Our Ref: R/2020/17/A
File No: 2022/059877
Your Ref: SSD-12618001

Request for Advice – 104-116 Regent Street, Redfern – Student Accommodation (SSD-12618001)

Notwithstanding the above, the **City has reviewed the accompanying documentation and objects to the proposal** in its current form based on the following matters:

0m 1 2 2.5m
Scale 1:50

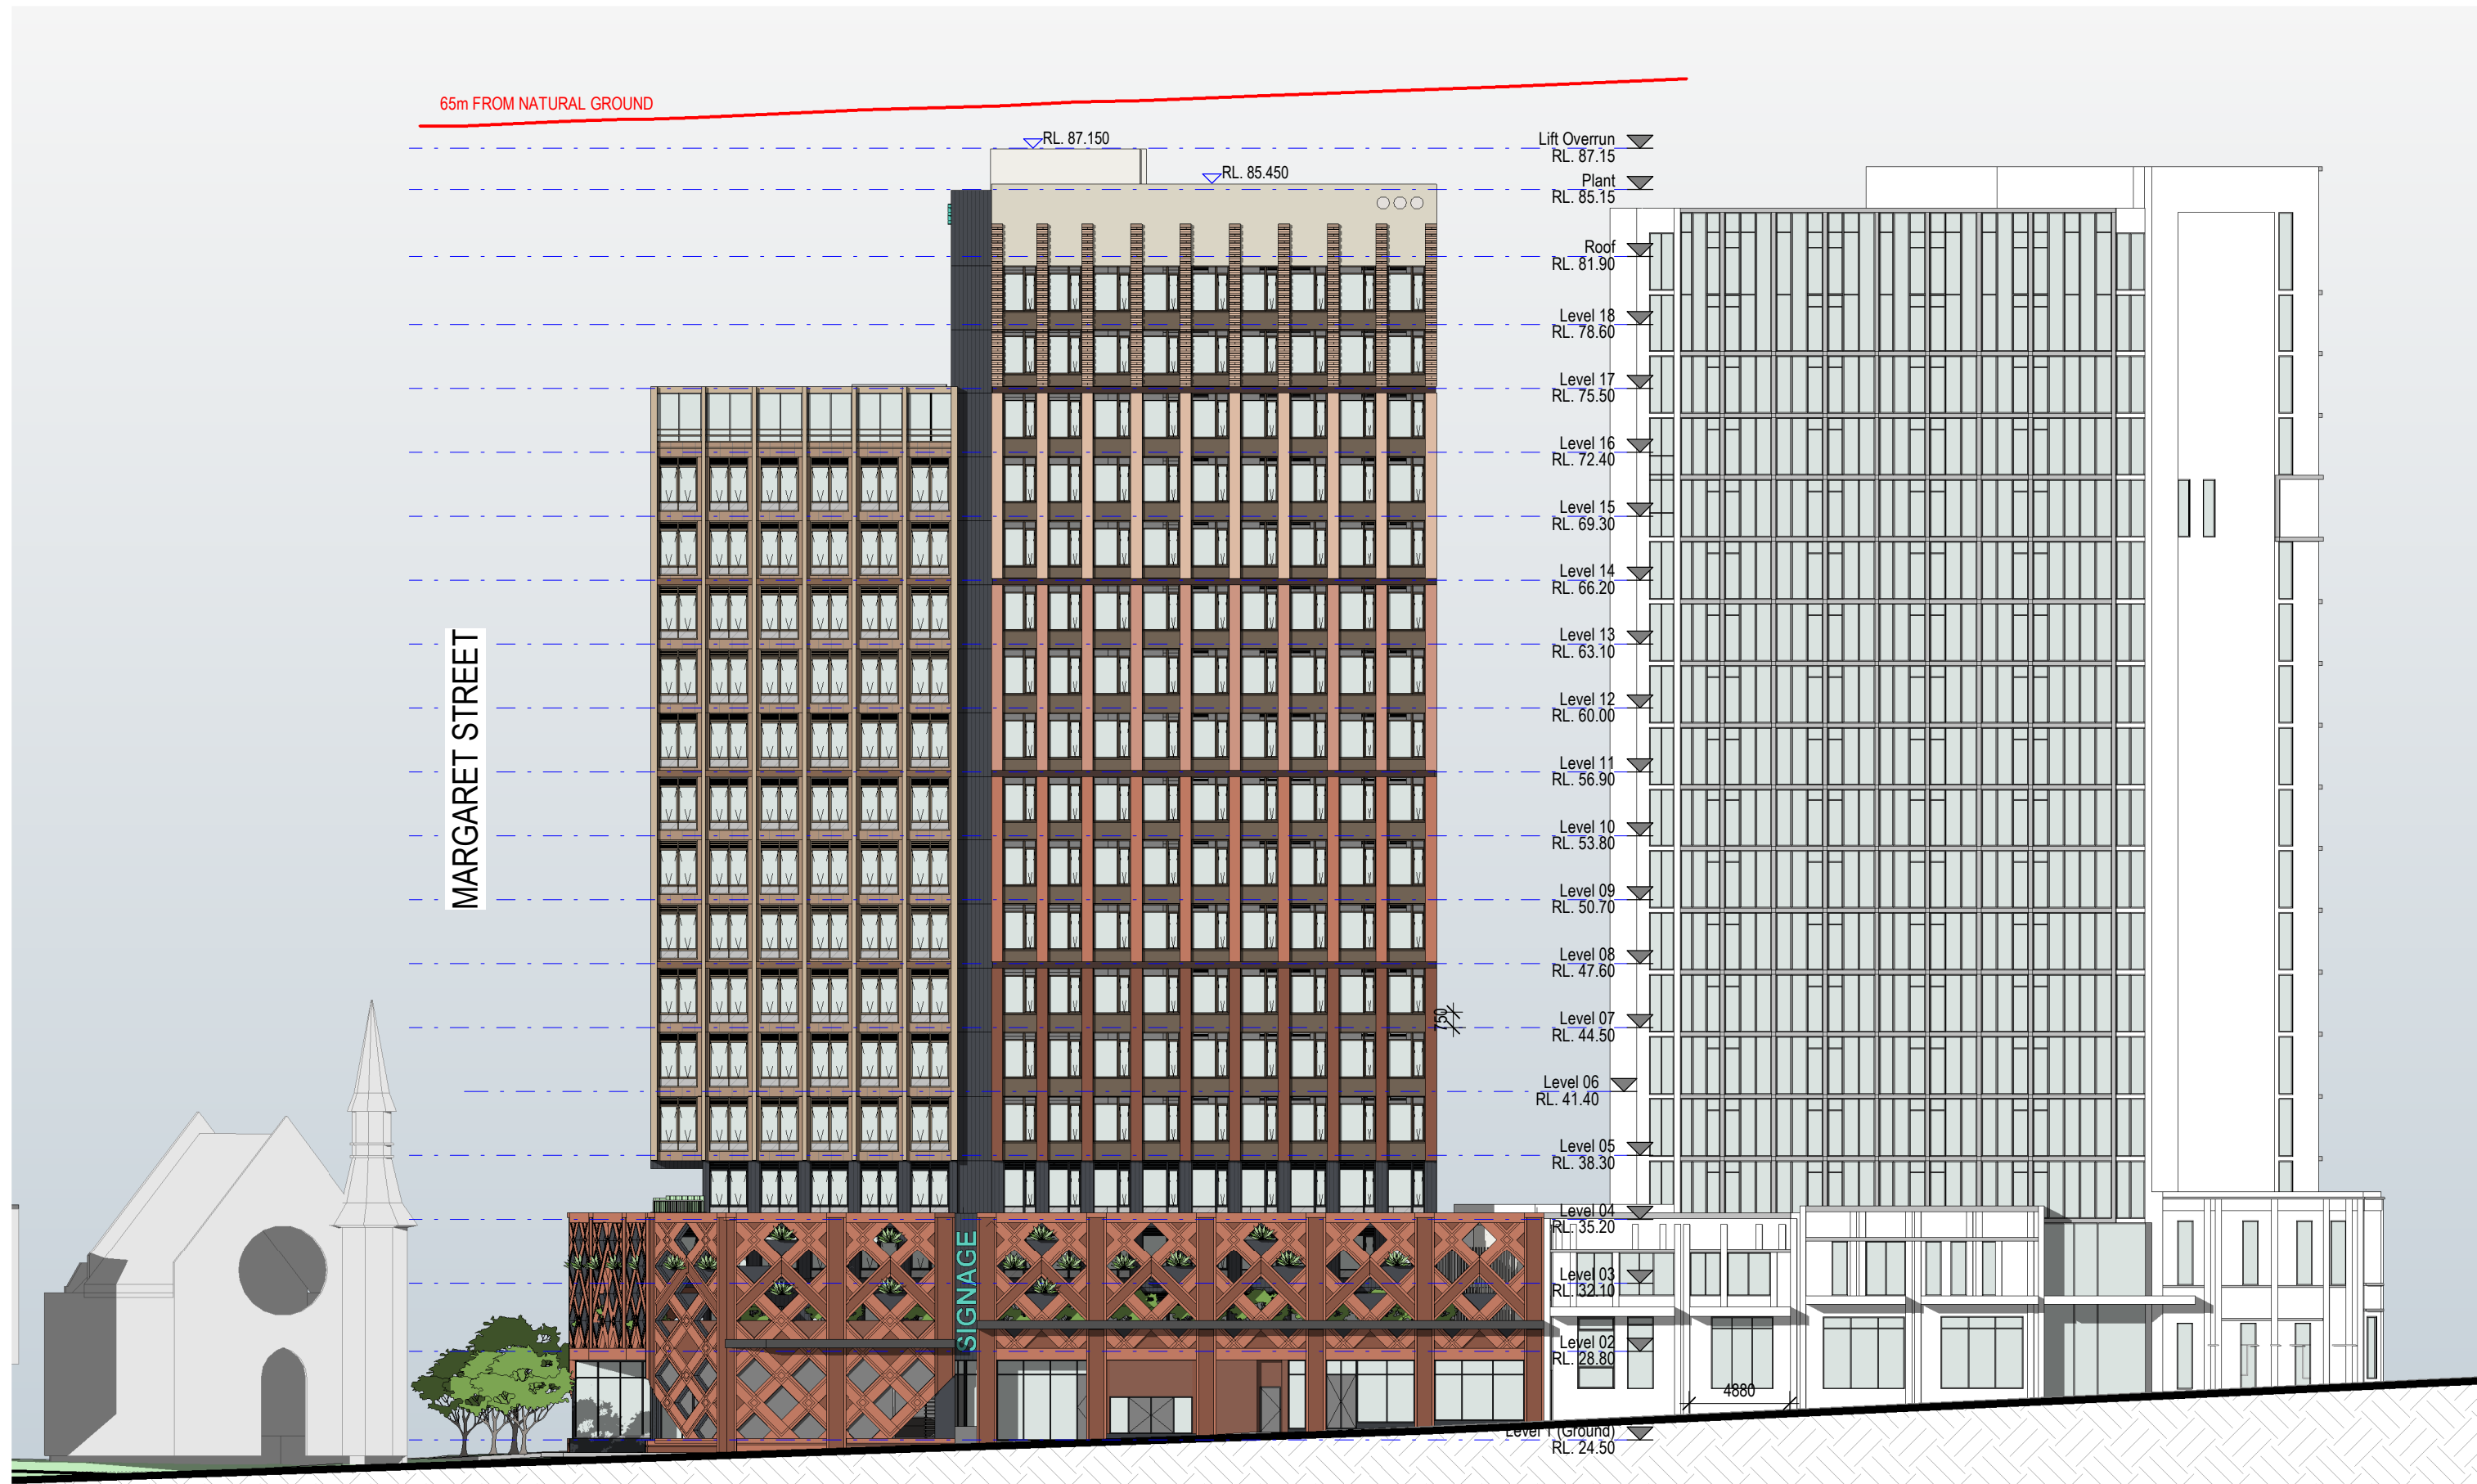
The Regent Street podium signage is not supported as it is not in accordance with RCUDP 3.4.2 signage requirements. An under-awning sign would be supported which assists identifying the entry to pedestrians.

Two top of building signs are proposed which contribute to visual clutter. The William Lane signage is recommended to be removed as this will be partially blocked by the Gibbons Street towers. The colour of the proposed signage is not supported as it highly contrasts and is not sympathetic with the proposed colour palette.
